RE: RESPONSE TO SUBMISSIONS MADE FOR SECTION 75W APPLICATION TO MODIFY  
DEVELOPMENT CONSENT FOR MP05\_0187: LOT 34 DP 1151746, JAMES CRAIG RD, ROZELLE

Our client, Longitude Rozelle Bay Pty Ltd ATF Sydney Slipways Unit trust (the Applicant), seeks to modify an existing consent to allow the installation of a light box feature on a building (known as Longitude) located at James Craig Road, Rozelle Bay (Lot 34 DP1151746). This letter responds to the two submissions received during the exhibition of the Application under Section 75W of the *Environmental Planning and Assessment (EP&A) Act 1979*.

Figure 2: Proposed lightbox located above existing stairwell

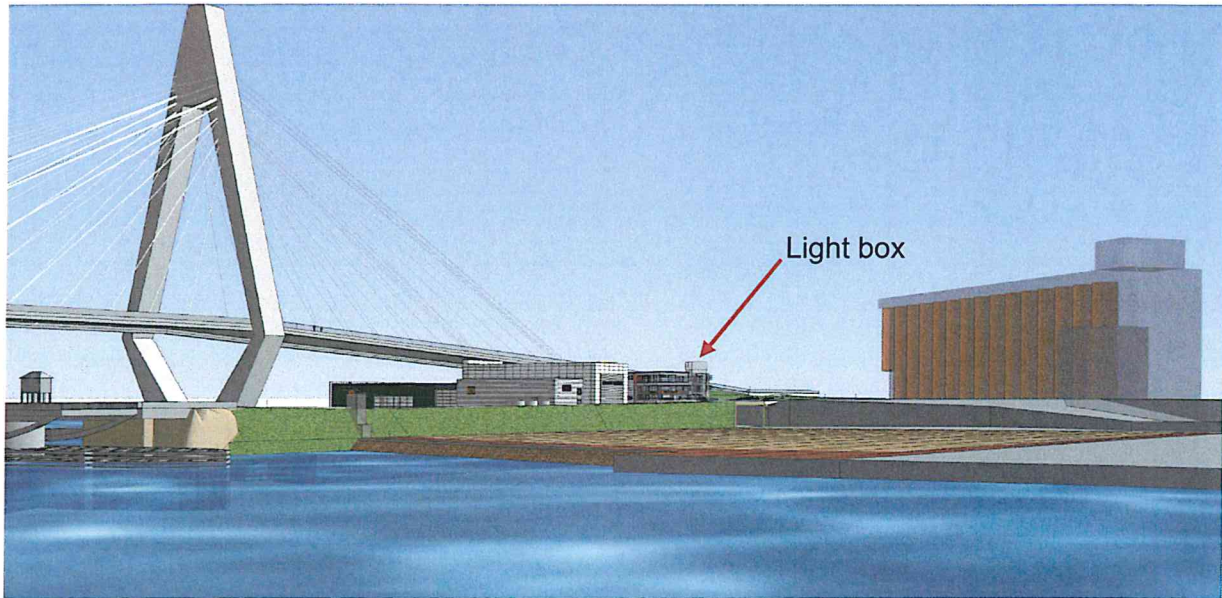
| Comments from Leichardt Council  | Applicant's Response   |
|--|--|
| <p><i>The proposed signage structure is not complementary to the building, but the nature of the surrounding area means this issue would have minimal impact.</i></p>  | <p>The proposed light box feature is complementary to the building. The light box would be on top of an existing stairwell. The stairwell provides articulation to the northern façade of the existing building.</p> <p>The architect specifically designed the light box to be the same dimensions as the northern stairwell. Therefore, the light box would be a natural protrusion of the stairwell and articulated form at this end of the building.</p>   |

Figure 4: Horizontal view impact from ANZAC Bridge to Sydney Harbour Bridge

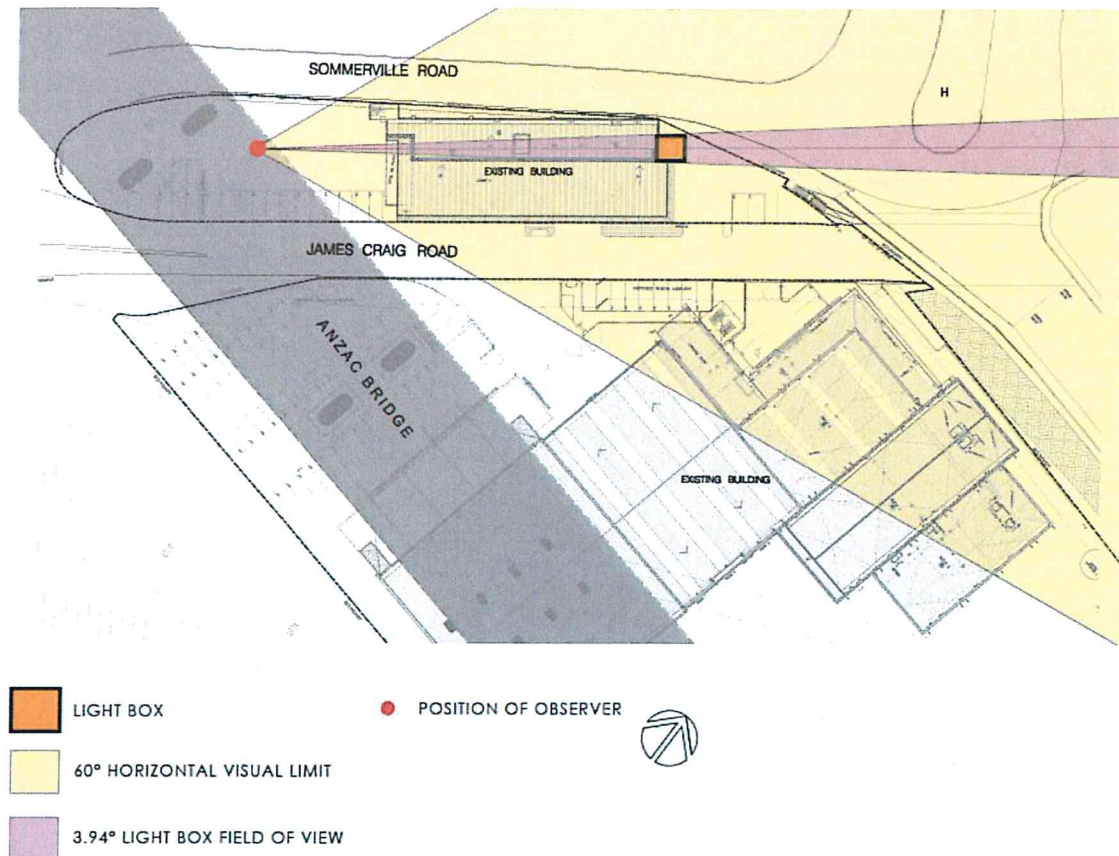
| Comments from Leichardt Council  | Applicant's Response  |
|--|---|
| <p><i>the DCP for SREP (Sydney Harbour Catchment) 2005 in relation to the following clauses:</i></p> <p><i>Section 3.2- General Aims: "all development should aim to: minimise any significant impact on views and vistas from and to: - public places, landmarks identified on the maps accompanying the DCP, and heritage items."</i></p> <p><i>Section 5.3 – Siting of Buildings and Structures: "buildings should not obstruct views and vistas from public places to the waterway; buildings should not obstruct views and vistas from public places to the waterway; buildings should not obstruct views of landmarks and features identified on the maps accompanying this DCP"</i></p> | <p>on views and vistas. There are no public places or landmarks identified on Map 8 (which includes the site) of the DCP. The nearest heritage site is the Grain Silos. The proposed light box would obscure a very small portion of the grain silos when viewed from Rozelle Bay or the Anzac Bridge through the guard rails. The assessment also considers views from the Anzac Bridge and found the light box would only obscure a portion of the flitting panoramic views through the existing guardrails when pedestrians, cyclist and drivers travel over the Anzac Bridge. The profile of proposed light box is relatively small and the surrounding environmental and built features of the locality would remain dominant.</p> |
